KITTITAS COUNTY DEPARTMENT OF PUBLIC WORKS

MEMORANDUM

TO: Jeff Watson, Community Development Services
FROM: Christina Wollman, Planner II *CW*
DATE: April 22, 2013
SUBJECT: Haberman BL-13-00005

# PART OF THE SOUTHEAST QUARTER OF SECTION 8, TOWNSHIP 17 NORTH, RANGE 19 EAST, W.M.

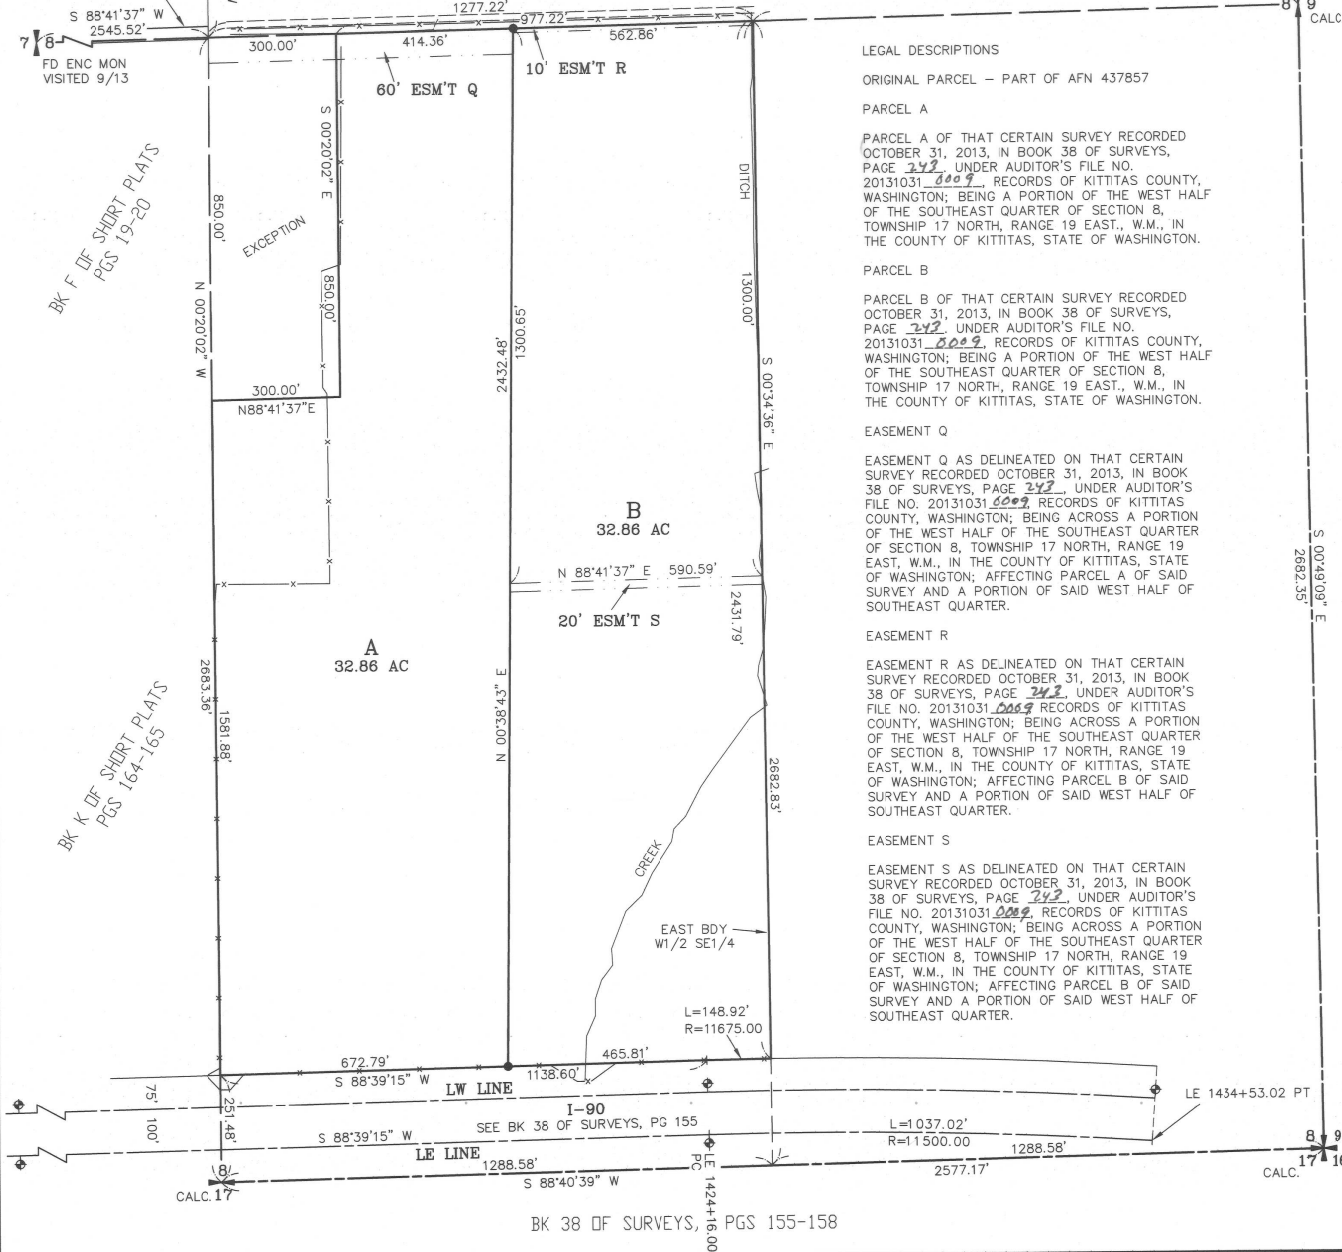
1. A revised legal description that describes the final configuration of the subject property shall be required.
